MONA OFFSHORE WIND PROJECT

Response to October Hearing Action Points

Application Reference: EN010137

Document Reference: S_D4_6

Figure 2.1: Queen scallop grounds fished by Scottish vessels within the Mona Array Area. Grounds are categorised by WCSP into red, pink, yellow, and green zones, with the red zone being defined as the ‘Very Important’ queen scallop fishing ground.

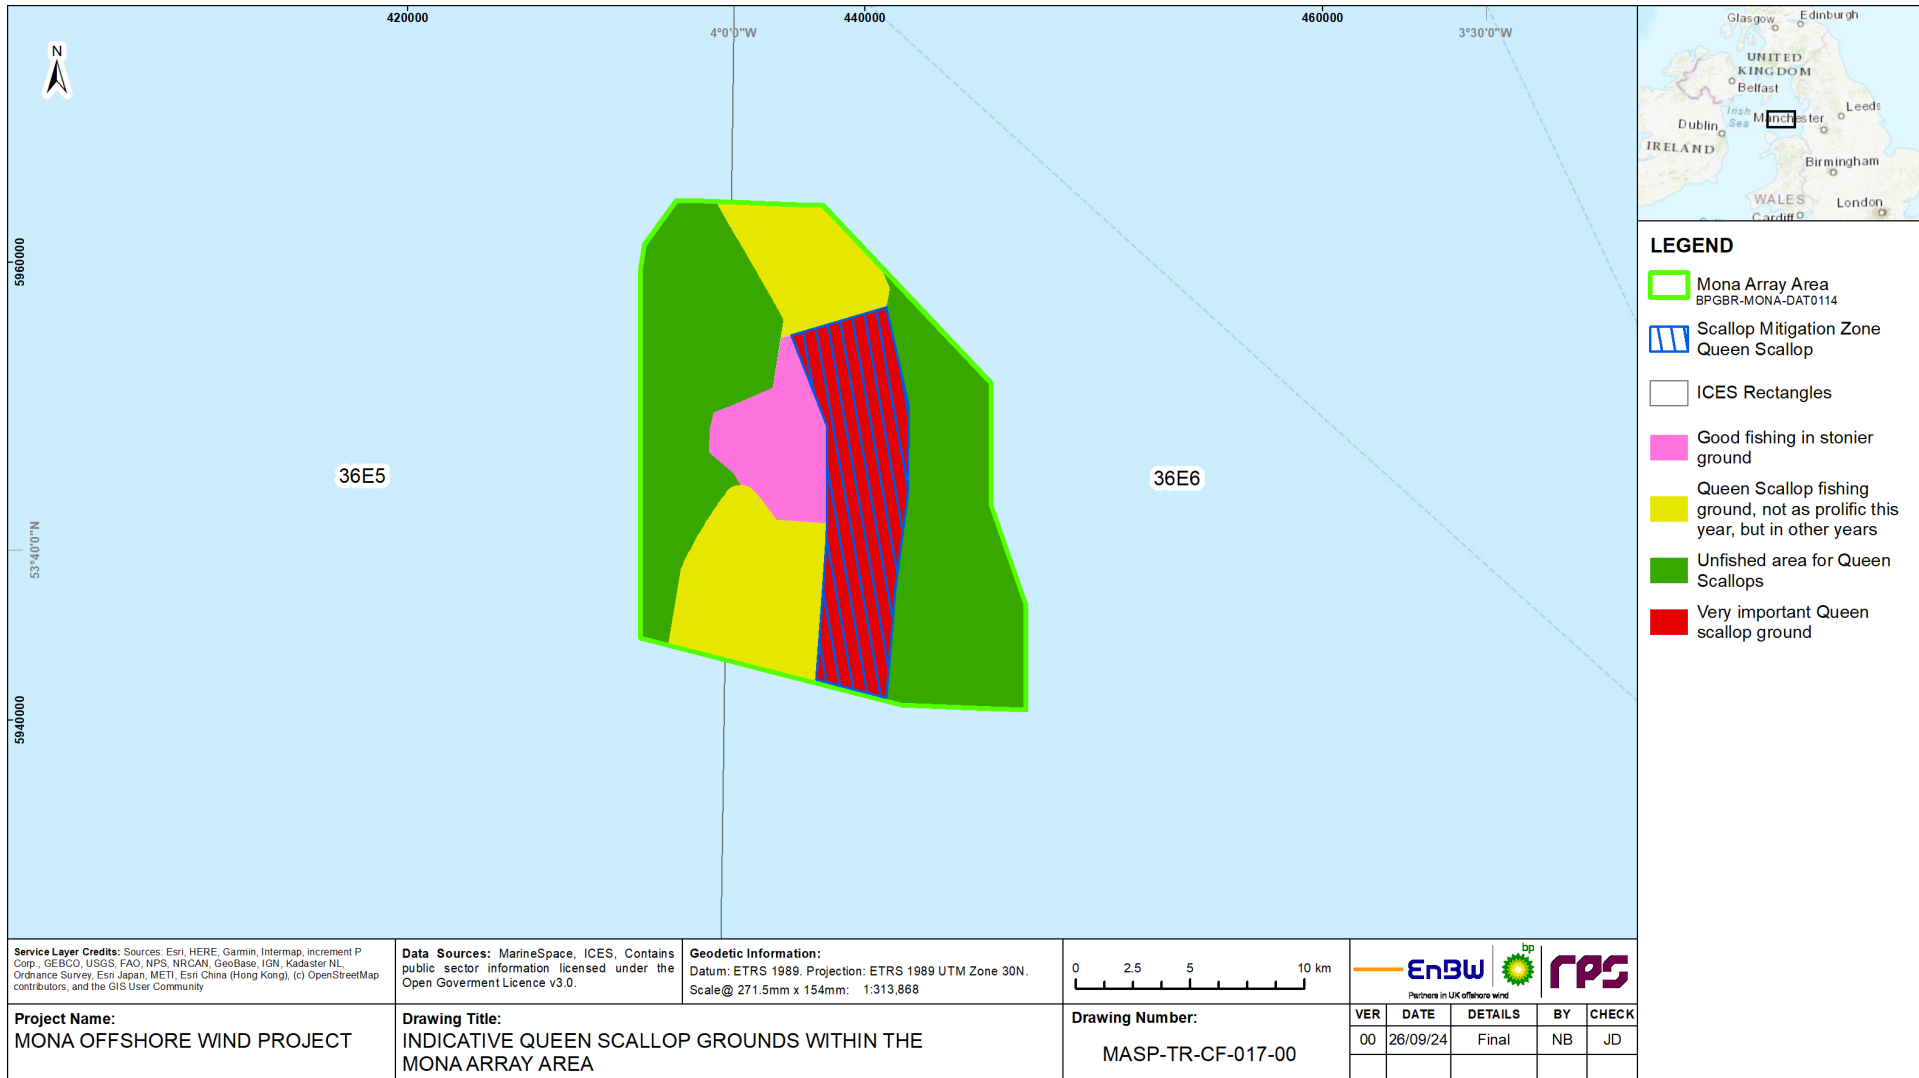
HAP_ISH4_17	Scottish Whitefish	Provide the surface area in sq. kilometres of the yellow shaded area (queen scallop fishing ground)	The Applicant has responded in section 5a of the Hearing Summary (ISH4): Offshore Matters (S_D4_4).

Ref.	Directed to	Action	Applicant's response
	Producers Association	and pink shaded area (queen scallop good fishing stonier ground) on Figure 2.1 of [REP3-066].	The Applicant notes that this action has been assigned to the Scottish Whitefish Producers Association, however the requested areas have been calculated by the Applicant for the purpose of providing a response to HAP_ISH4_18 below.
HAP_ISH4_18	Applicant	<p>The minimum distance of 1.4km between each wind turbine generator (WTG), would result in a higher capacity density than 6.2 MW/Km2 noted in Scallops Mitigation Zone document [REP3-066]. Can the Applicant advise what would be the effect on capacity density if the size of scallops mitigation zone would be increased to include the following scenarios:</p> <ul style="list-style-type: none"> i) Yellow shaded area (queen scallop fishing ground) ii) pink shaded area (queen scallop good fishing stonier ground) iii) combination of yellow and pink shaded area 	<p>Capacity density is the target capacity of a wind farm at the onshore grid connection point divided by the area of the wind farm. As the area of a wind farm decreases, the capacity density increases in line with a reduction in spatial flexibility, the ability to manage layout constraints and the ability to maximise capacity and energy generation of the Project. As stated within the Applicant's response to ExQ1 Q1.5.1 (REP3-066), The Crown Estate limited 'Round 4' bids to a maximum area based on a capacity density of 3 MW/km² and a requirement that at the point of entering into the lease post-consent, that the final capacity density of the wind farm is not less than 5 MW/km². With the commitment to the scallop mitigation zone (SMZ), the Mona array already has a capacity density of 6.2 MW/km² and has yet to finalise the layout and address known and unknown constraints.</p> <p>The effect on the capacity density from increasing the SMZ to cover the 3 new scenarios is given below. For each scenario, capacity density has been calculated by subtracting the SMZ plus the new scenarios from the total area of the Mona array to give the updated area available for installation of wind turbines generators (WTGs) and offshore substation platforms (OSPs). The target capacity at the onshore connection point of 1,500 MW is then divided by the updated area available for WTGs and OSPs.</p> <p>As a result, capacity density is increased from 6.2 MW/km² for the SMZ alone, to 6.9 MW/km² for Scenario 'ii', 8.6 MW/km² for scenario 'i' and 10.1 MW/km² for scenario 'iii' as set out in the calculations below.</p> <ul style="list-style-type: none"> • Scenario 'i': Yellow (68.7 km²) + Red i.e. SMZ (57.8 km²) = 126.5 km² (42% of the Mona Array Area based on 300 – 126.5 = 173.5 km²). The resulting capacity density is 1500 MW ÷ 173.5 = 8.6 MW/km² • Scenario 'ii': Pink (25.4 km²) + Red i.e. SMZ (57.8 km²) = 83.2 km² (28% of the Mona Array Area based on 300 – 83.2 = 216.8 km²). The resulting capacity density is 1500 MW ÷ 216.8 = 6.9 MW/km² • Scenario 'iii': Yellow (68.7 km²) + Pink (25.4 km²) + Red i.e. SMZ (57.8 km²) = 151.9 km² (51% of the Mona Array Area based on 300 – 151.9 = 148.1 km²). The resulting capacity density is 1500 MW ÷ 148.1 = 10.1 MW/km²
